SUBJECT: Engineering Review Comment
Mountain View Electric Association Inc. (MVEA)

Project Name: Osban Final Plat – Lot 1, Rolling Hills Ranch Estates Filing 3

Project Number: SF2423

Description: Proposed development of 1 residential lot located at 525 S. Page Rd.
in Township 14S, Range 63W, Section 18.

SEPTEMBER 24, 2024 Sheet 2 of 2

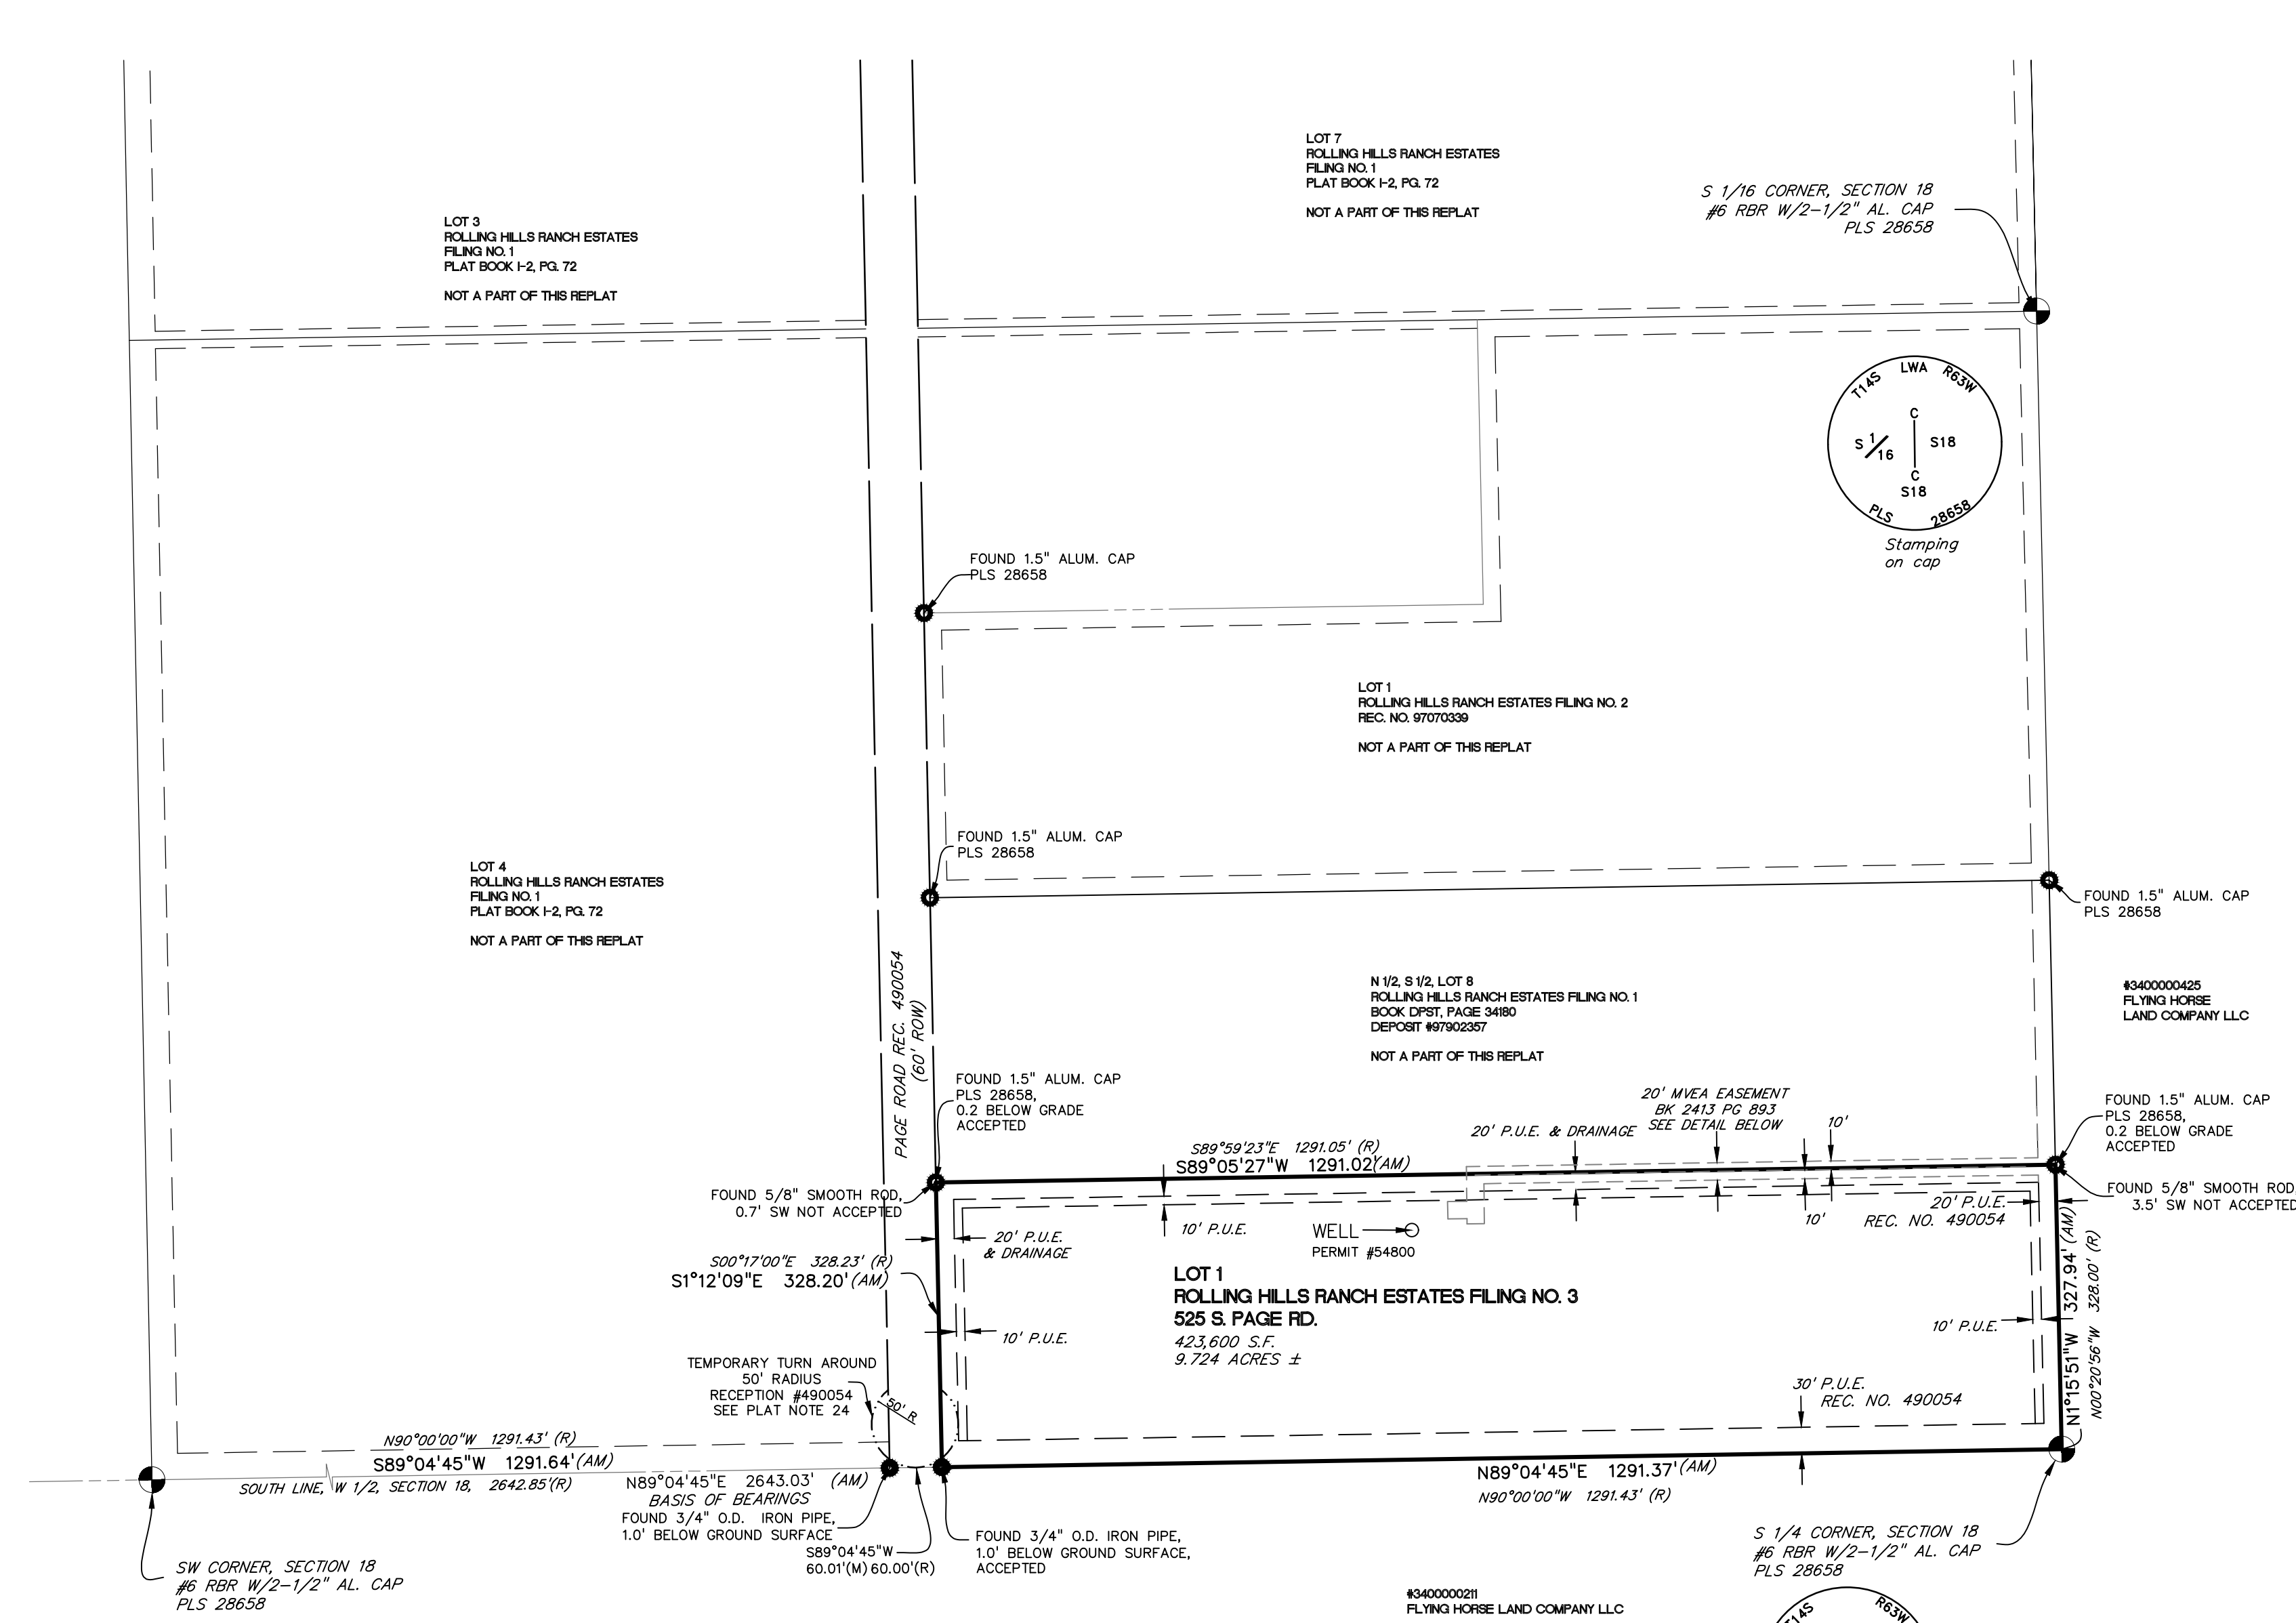
MVEA requests a ten (10) foot front, side, and rear lot utility easements on the plat. MVEA also requests the platting of MVEA's existing facilities with easements on the plat. Additional easements may be required.

MVEA has existing facilities near and within this parcel of land. If there is any damage, removal or relocation of facilities it will be at the expense of the applicant.
